Planning Application Ref: AW/305/17/T

Location : 8 Apple Grove, Aldwick

Description of works: Remove 4m off southwest facing bough & deadwood 1 No Monterey Pine

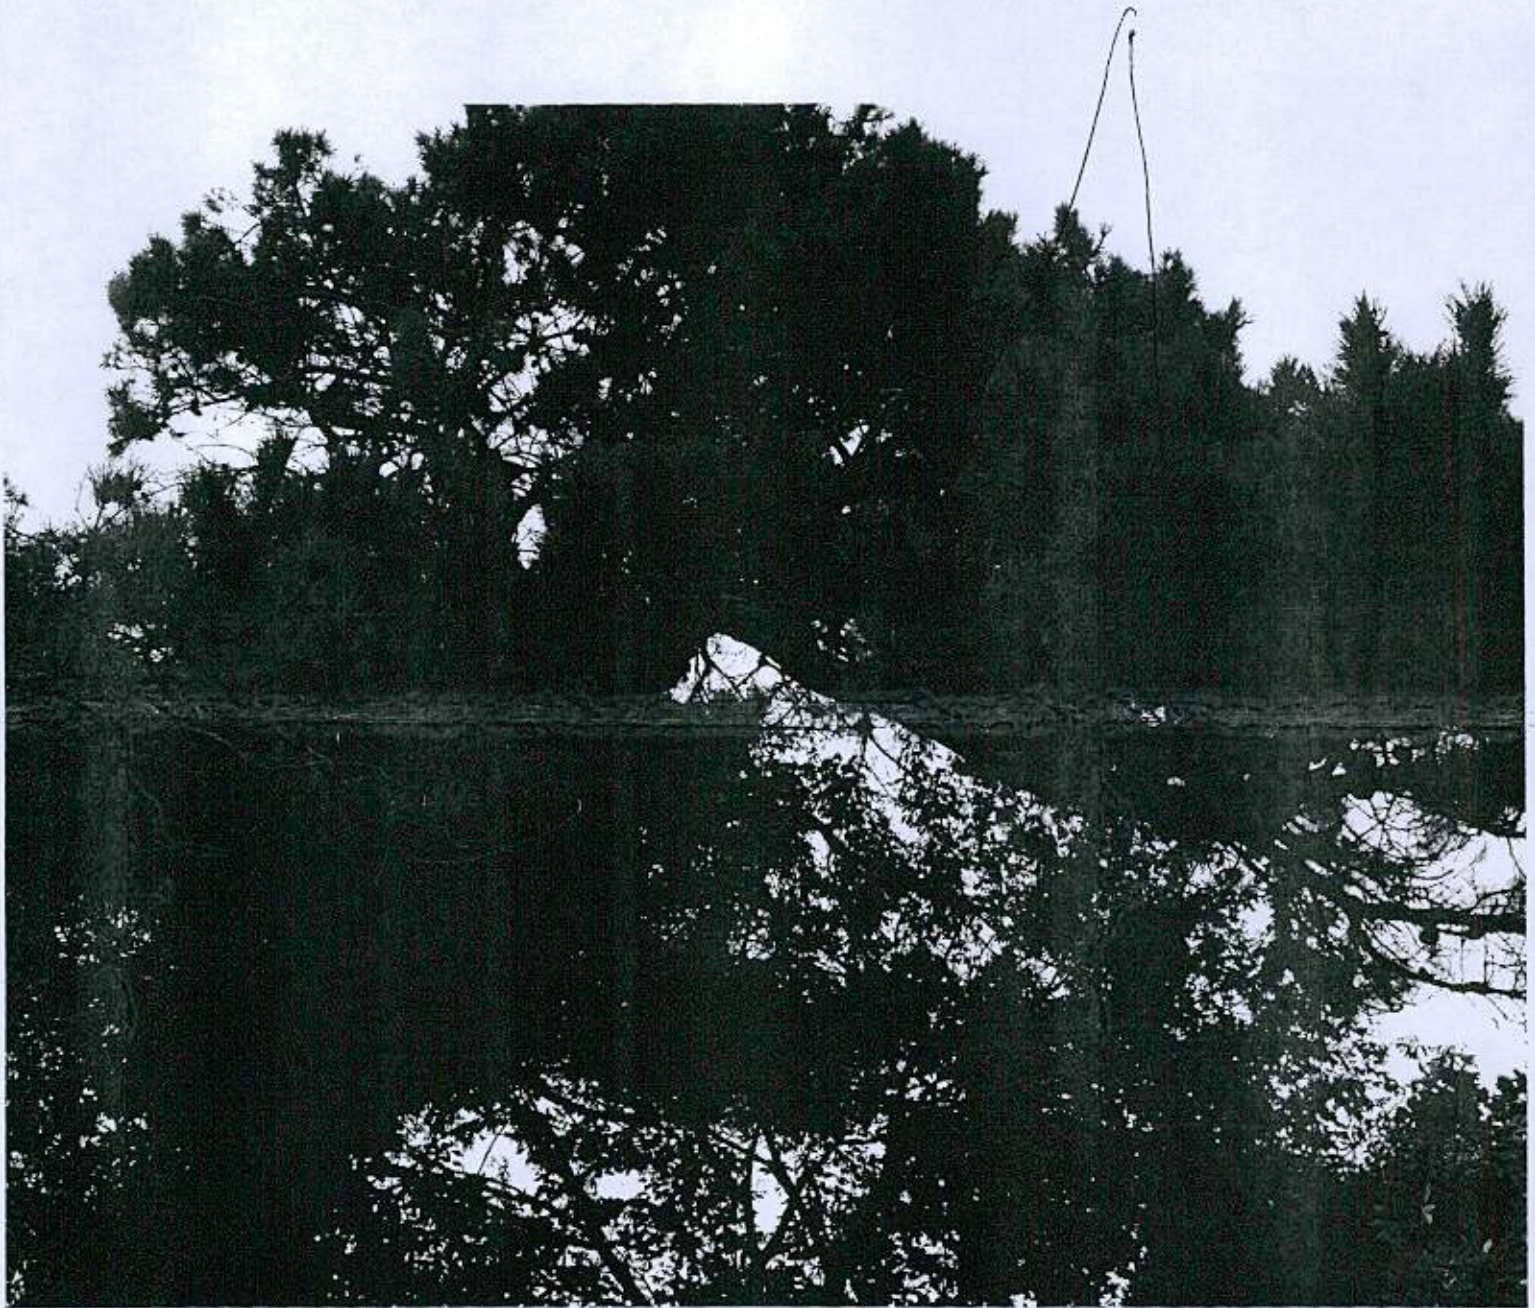
- Situated in the small rear garden of this property.
- Sound and healthy tree that is visually significant in the landscape.
- Has one low attenuated limb to the southwest facing side that is out of character with the remainder of the crown.
- Due to the dark foliage this tree causes light issues all year round.

- This shortening back of the low limb will provide significant benefit for the owners without detracting from this trees visual amenity value in the landscape.
- The removal of deadwood does not require Council approval.

- I recommend **APPROVAL** for the works as listed.

- Where branches are to be shortened back the final cuts are to be made at the correct angle shown in BS3998:2010 and adjacent to a live bud or lateral.
